**RE: MAJOR PROJECT APPLICATION: MP 06\_0205  
MODIFICATION NO 3  
RESPONSE TO SHOALHAVEN CITY COUNCIL SUBMISSION**

Further to Shoalhaven City Councils submission to DoP dated 9 June 2011, Ref 3A08/1006, we respond as follows;

Appendix 1 – Traffic Unit Response

MOONA CREEK ROAD, ENTRY PLAZA TO TOWN CENTRE & ARBOURWALK

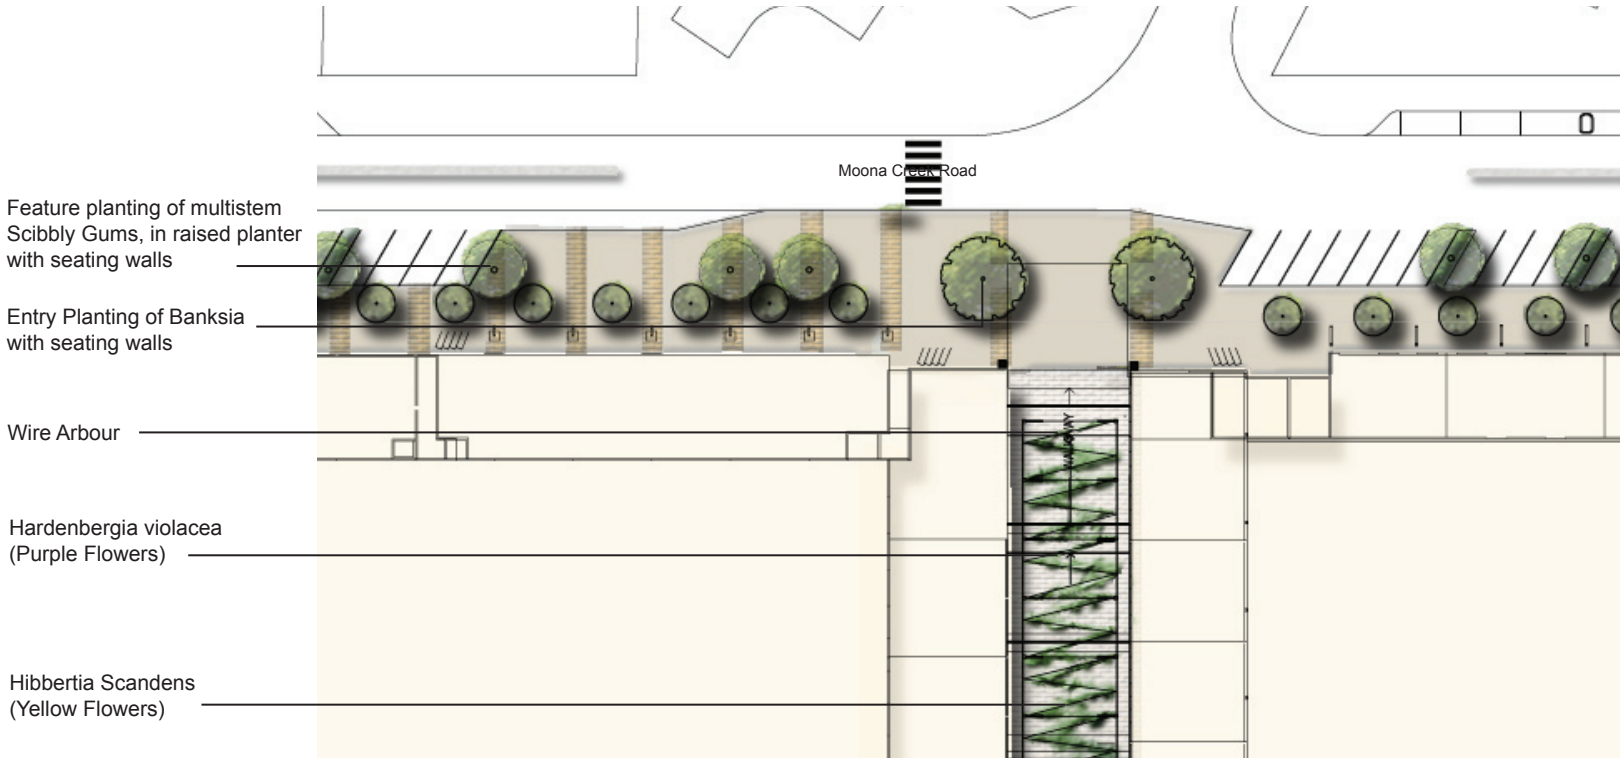
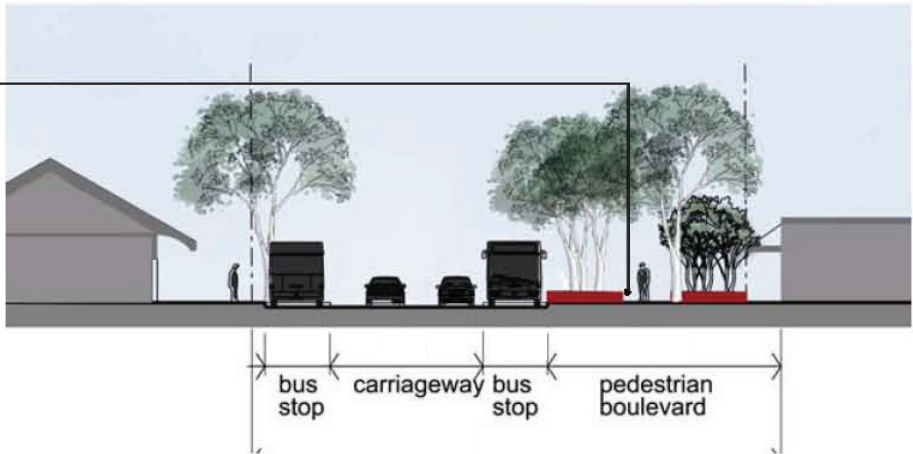
- *Moona Creek Road (between Naval College Road and the car park access) > two lanes northbound in Moona Creek Road including a single through lane and a single separate right turn bay (right turn lane) for protection of traffic turning into the car park. The applicant advises this has been incorporated, however Council has not seen revised plans. It is not reflected on the Modification 3 plans.*

- *Moona Creek Road (between Naval College Road and the car park access) > two lanes southbound (exit to Naval College Road). The applicant advises this has been incorporated, however Council has not seen revised plans. It is not reflected on the Modification 3 plans.*

- *Moona Creek Road (between Naval College Road and the car park access) > median; of minimum 900mm width (include RTA pedestrian fence along full length of median in this section). If no fence is proposed by the applicant a wider median would be required. 2m would be the suggested minimum median width. On the basis of suggested additional parallel parking on the western side of Moona Creek Road the 900mm median and RTA standard pedestrian fence should be provided along this full length. It is not reflected on the Modification 3 plans. Any additional parking in this section shall be west side (parallel) only and appropriate for use by long vehicle parking only.*

- *Moona Creek Road (intersection with car park access) > design must ensure that all traffic exiting the car park be forced to turn left out only by way of physical traffic island. Traffic Unit consider that it would be unsafe to allow traffic to turn right out at this location. Traffic may turn "in" to the car park from either direction. It is noted that the applicant has not accepted this restriction however Council as the roads authority will not approve plans without such restriction so it should be incorporated in to the design. If traffic is delayed at the car park access motorists can turn left and go around the roundabout. This is exactly what Council are suggesting however to eliminate the risk of incidents Council require physical works to force traffic to turn left out only. This is not a major works requirement and should be addressed. It is not reflected on the Modification 3 plans.*

- *Moona Creek Road (between car park access and Halloran Street) > single lanes in each direction accepted. On the basis of suggested bus stops and additional parallel parking on the western side of Moona Creek Road there must be minimum 900mm median and RTA standard pedestrian fence should be provided along this full length. This is not reflected on the Modification 3 plans. A wider median (suggested minimum 2m) in conjunction with RTA standard pedestrian fencing should be considered on the basis this would present opportunities for land scaping along the median which would improve the appearance and amenity of the area. Parking in this section shall comprise west side (parallel) appropriate for use by long vehicle parking only. The bus bay (west side) needs to be amended to comply with AUSTROADS standards. The bus bay (east side) needs to be amended to comply with AUSTROADS standards. Parking in this section shall comprise east side (parallel parking only which shall include taxi and community bus zone and any residual kerb length can be allocated to general purpose parking with appropriate time restrictions).*

- *Moona Creek Road (between Halloran Street and eastern roundabout) > single lanes in each direction is accepted; and median; of minimum 2m width. No fence required along this section of median, however landscaping could be provided to improve the appearance and amenity of the area with designated pedestrian crossing points. On street*

*car parking shall be parallel (west side) and 45 degree (rear in) east side. The cross section shall be (east to west): 3.6m footpath reserve, 9.8m allowance for 45 degree angled car parking bays (reverse in only) and southbound traffic lane, 2m median, 3m northbound traffic lane, 3m northbound parallel parking lane, and 3.6m footpath reserve (total 25m road reserve). Parking in this section of Moona Creek Road shall be time restricted (both sides) to prevent all day use by employees of the centre.*

Cardno Response: Due to the scale of the architectural and civil drawings it may not be clear as to exactly how many lanes are provided for in this section of Moona CK Rd. However, Cardno Drawing 8016 Rev P0 dated 3.10.08 is the current approved layout for Moona CK Rd and this drawing clearly indicates the provision of two northbound lanes. The single through lane and right turn lane will be provided in the detailed design phase for Moona CK Rd. In this regard Cardno will provide to Council in due course concept design plans for Moona CK Rd with the view of undertaking a concept review with Council prior to finalisation of the detailed design.

Cardno Response: Due to the scale of the architectural and civil drawings it may not be clear as to exactly how many lanes are provided for in this section of Moona CK Rd. However, Cardno Drawing 8016 Rev P0 dated 3.10.08 is the current approved layout for Moona CK Rd and this drawing clearly indicates the provision of two northbound lanes. The single through lane and right turn lane will be provided in the detailed design phase for Moona CK Rd. In this regard Cardno will provide to Council in due course concept design plans for Moona CK Rd with the view of undertaking a concept review with Council prior to finalisation of the detailed design.

**Cardno Response:** The parking on the west side of Moona CK Rd will remain as parallel parking and will be marked as long vehicle parking. It is the intention to provide the 900mm wide median and pedestrian fence as per Councils comment and these details will be finalised prior to the concept design plans being lodged with Council for review.

**Cardno Response:** It is the intention to restrict turning out of the southern carpark entrance to Moona CK Rd to left turn only as per Councils comment. These details will be finalised prior to the concept design plans being lodged with Council for review.

**Cardno Response:** The parking has been amended as per Councils comments. The bus bays have been confirmed as complying with Austroads standards. A decision is yet to be made on the size of the central median (900mm or 2000mm) and this will need to be discussed between Fabcot and Stockland. In this regard Cardno will provide to Council in due course concept design plans for Moona CK Rd with the view of undertaking a concept review with Council prior to finalisation of the detailed design.

Cardno Response: The suggestions by Council above for the section of Moona Ck Rd between Halloran St and the eastern roundabout have been considered and accepted. Due to the scale of the architectural and civil drawings drawings however, it may not be clear in intricate detail. Cardno will provide to Council in due course concept design plans for Moona CK Rd with the view of undertaking a concept review with Council prior to finalisation of the detailed design.
